# CITY OF ALBUQUERQUE

March 7, 2019

RE: **1<sup>st</sup> Nations Community Healthsource (Bldgs A &B)**  
**5608 Zuni SE**  
**Request for Certificate of Occupancy – Temporary**  
**Hydrology Inspection - Approved**  
**Grading and Drainage Plan Stamp Date: 1/17/18**  
**Certification Dated: 3/5/19**  
**Drainage File: L18D047**

C-100A

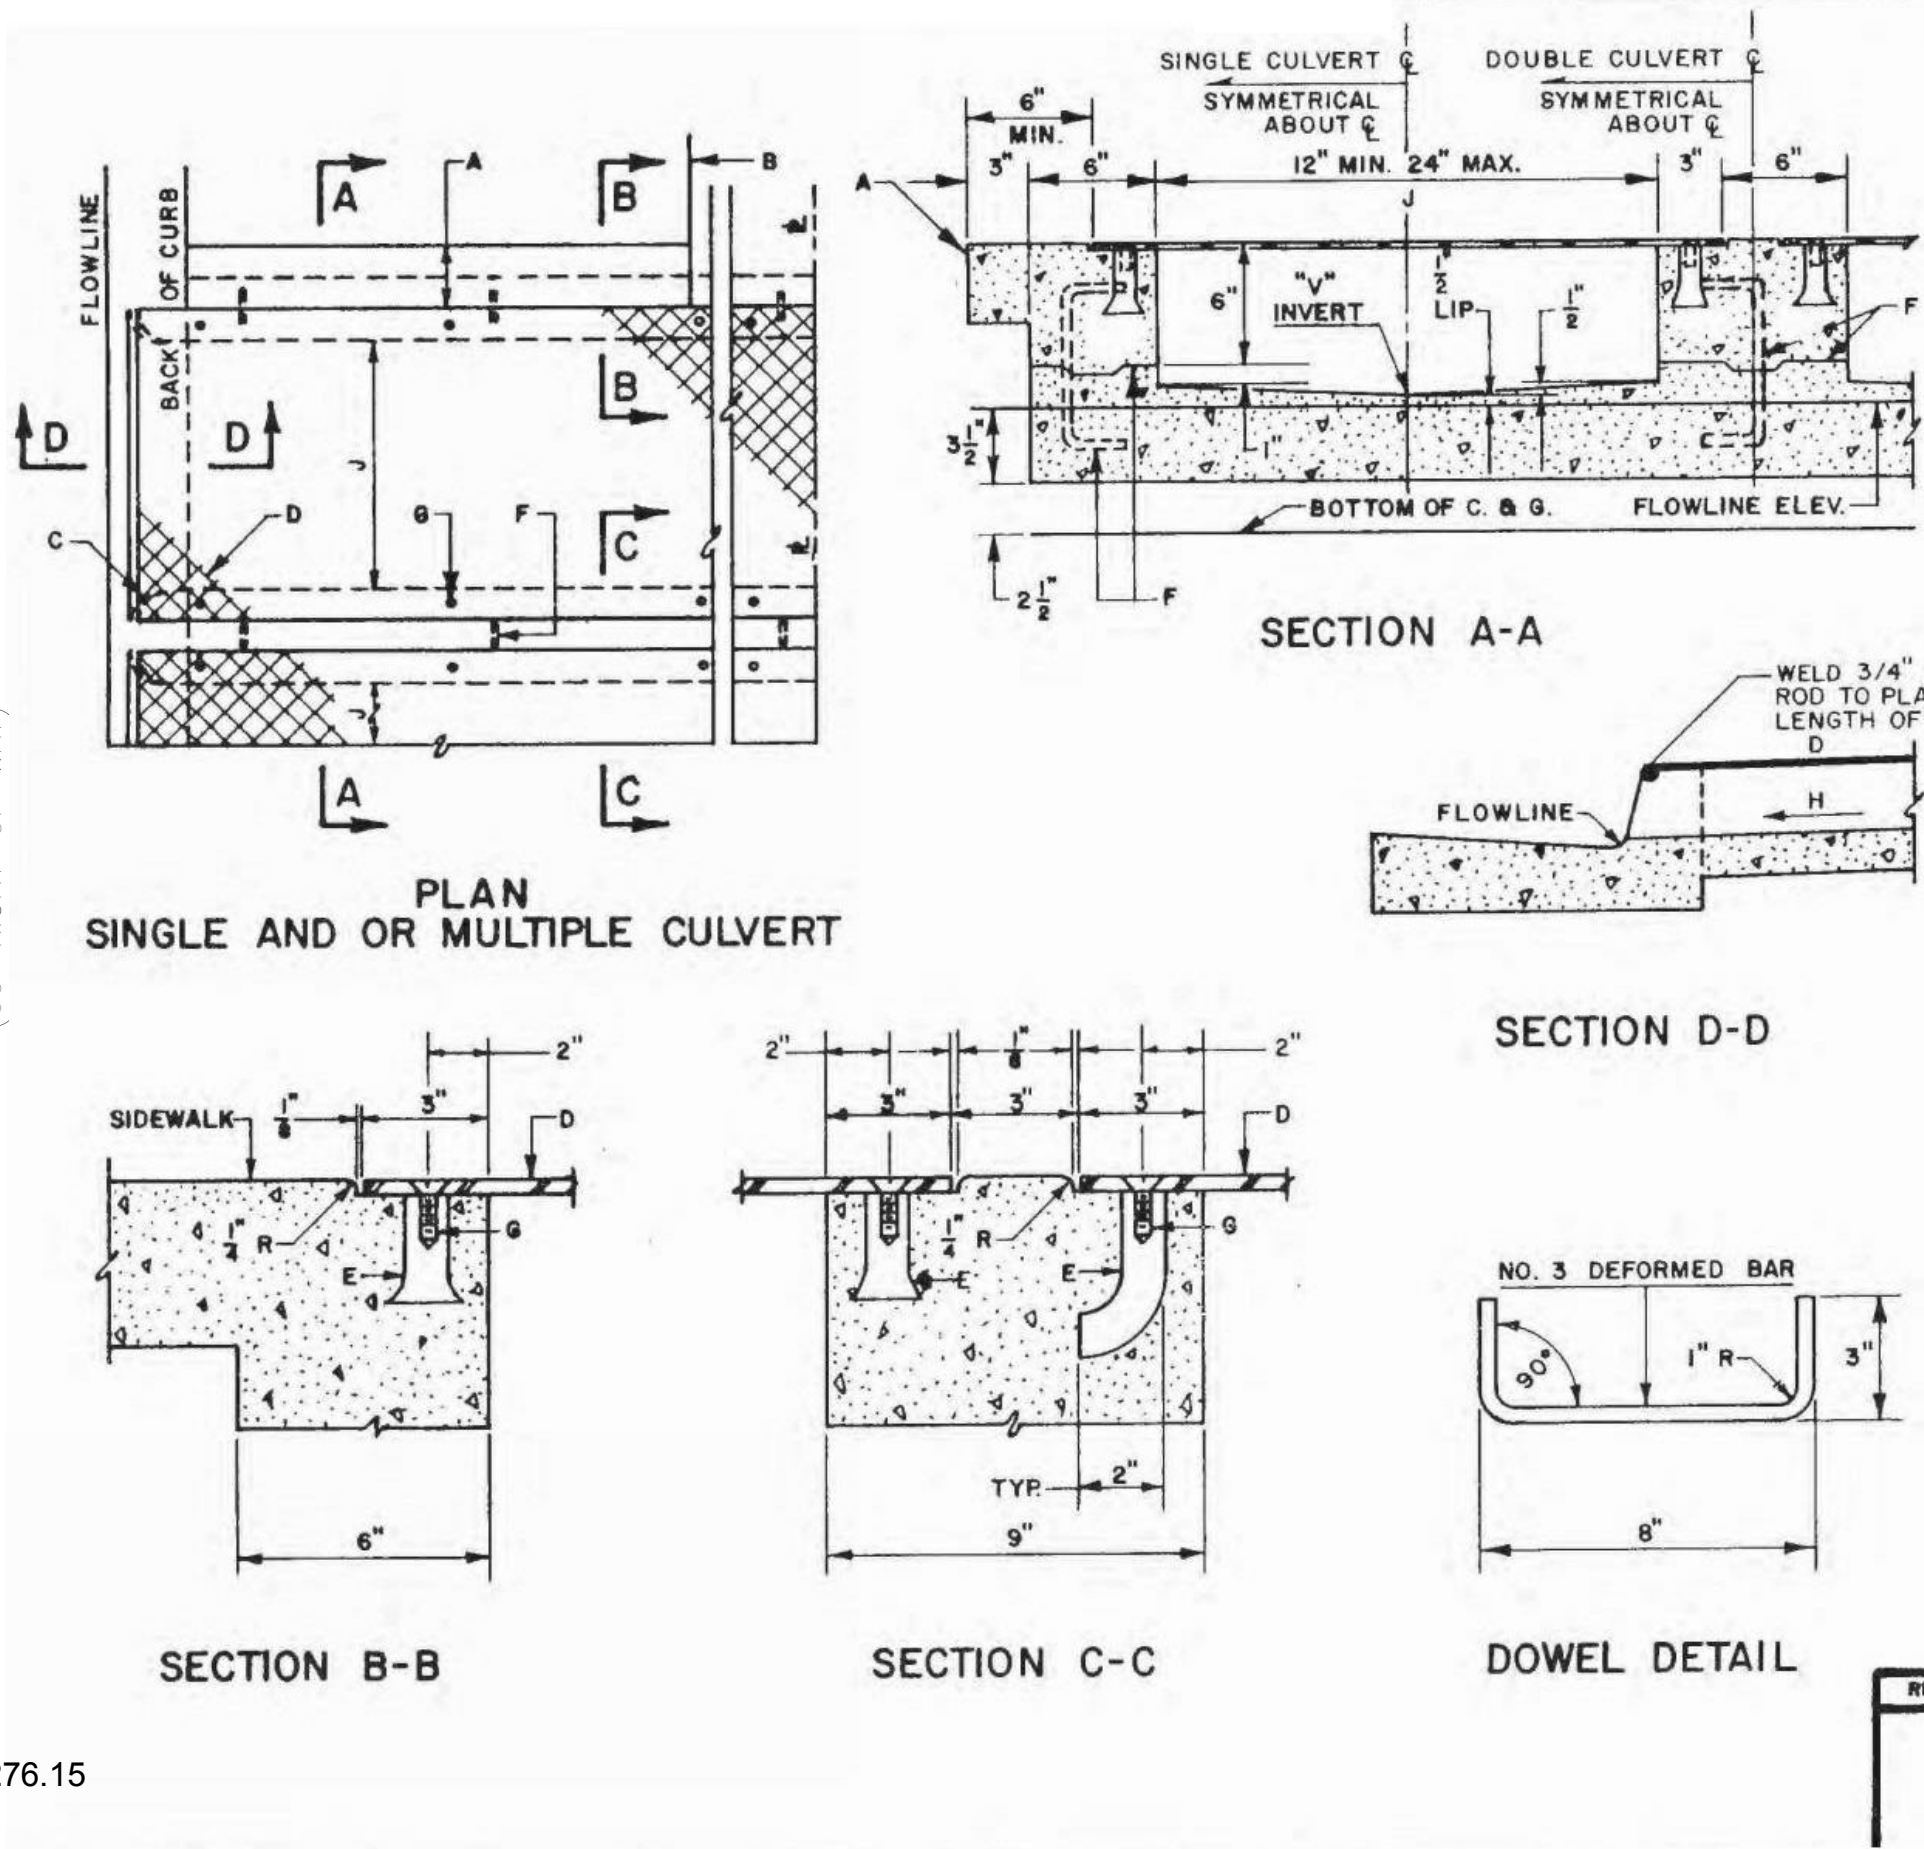
1. Provide an outfall to the ROW for the storm water pond to keep it from backing up and ponding in the south portion of the parking lot. Hydrology recommends a drain line or channel behind the dumpster pad with drain line through the curb to Palomas (Std Dwg 2225- requires an SO-19 Permit) or an asphalt cut with new valley gutter across the parking lot and out the drive entrance.
2. A new Engineer's Certification, per the DPM Chapter 22.7: *Engineer's Certification Checklist For Non-Subdivision* is required once the corrective measure is taken.
